Rezoning Transportation Analysis

Petition Number: 2021-079

DRAWING NO.: **RZ-01**

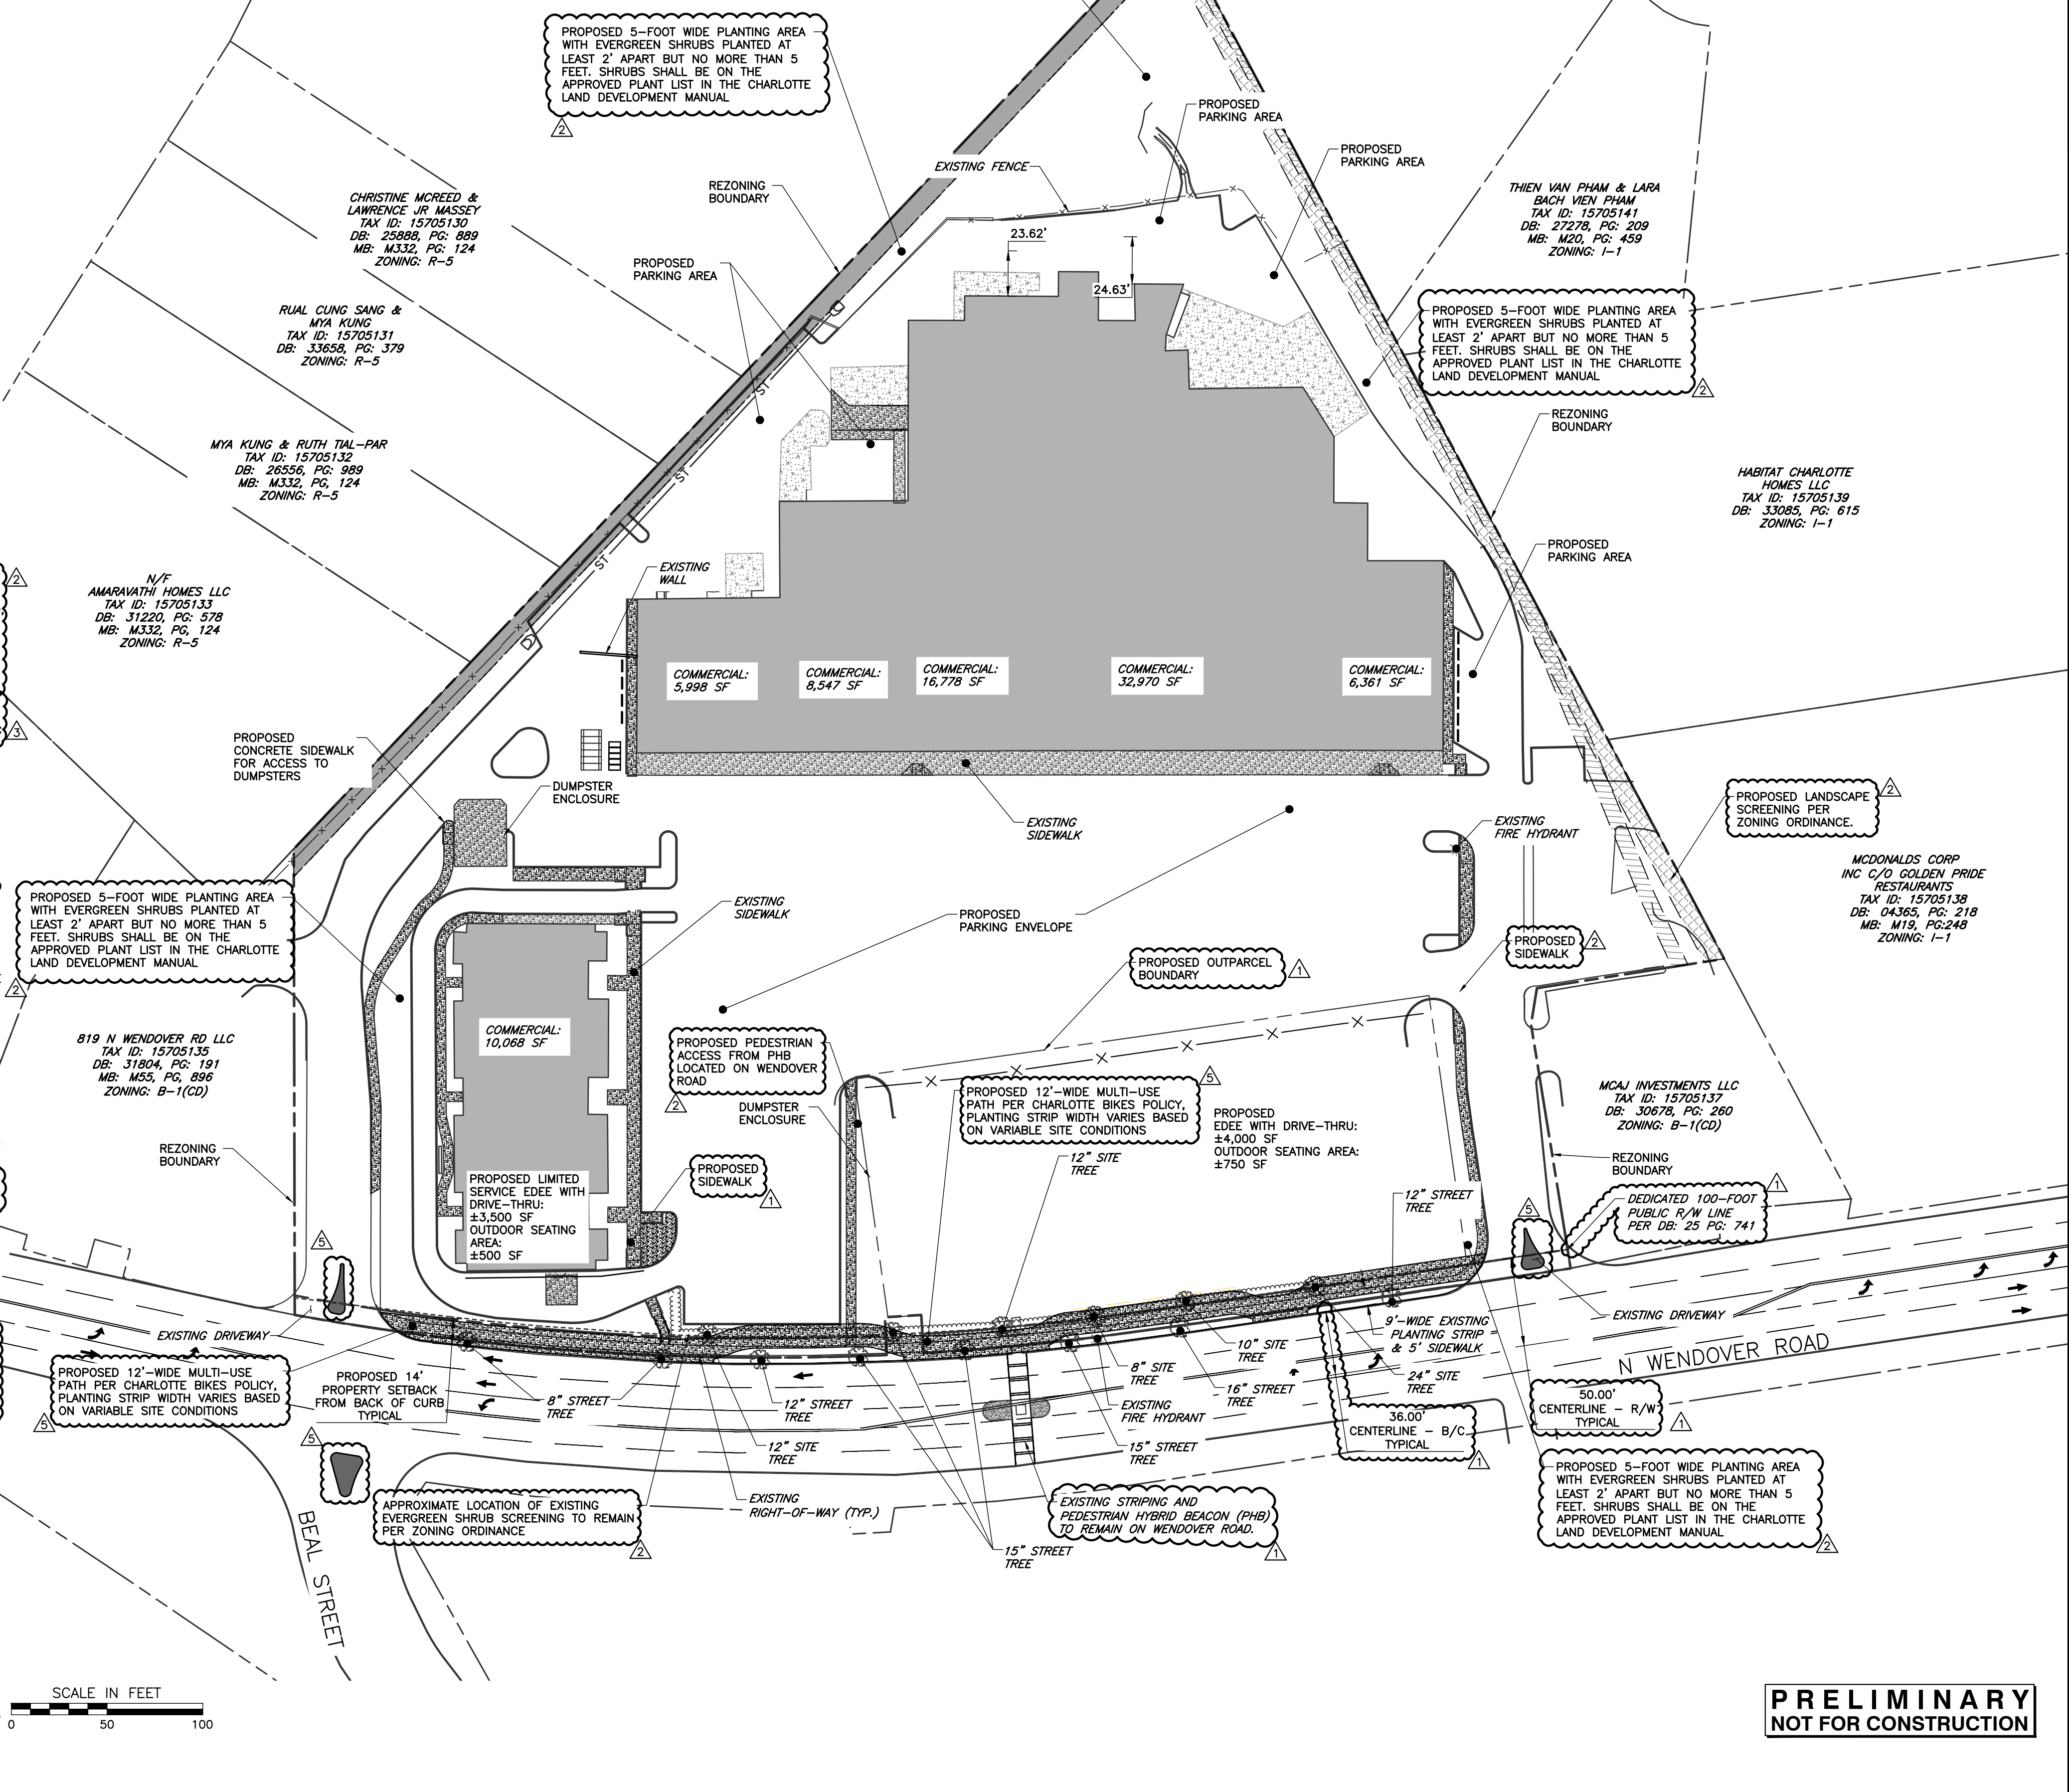
2. **Traffic Study:**

A Traffic Impact Study is necessary for the complete review of this petition due to the site generating more than 2,500 daily trips.

Staff will receive the petition and begin review, but the public hearing will not be scheduled until the TIS is approved to allow for the minimum time necessary for CDOT to review the study and reach agreement with the petitioner on the required transportation commitments. Any agreed upon commitments shall be included on the last site plan submitted no fewer than 4 weeks prior to the public hearing. Therefore, additional traffic mitigation comments may be forthcoming once the TIS is approved by CDOT (and NCDOT).
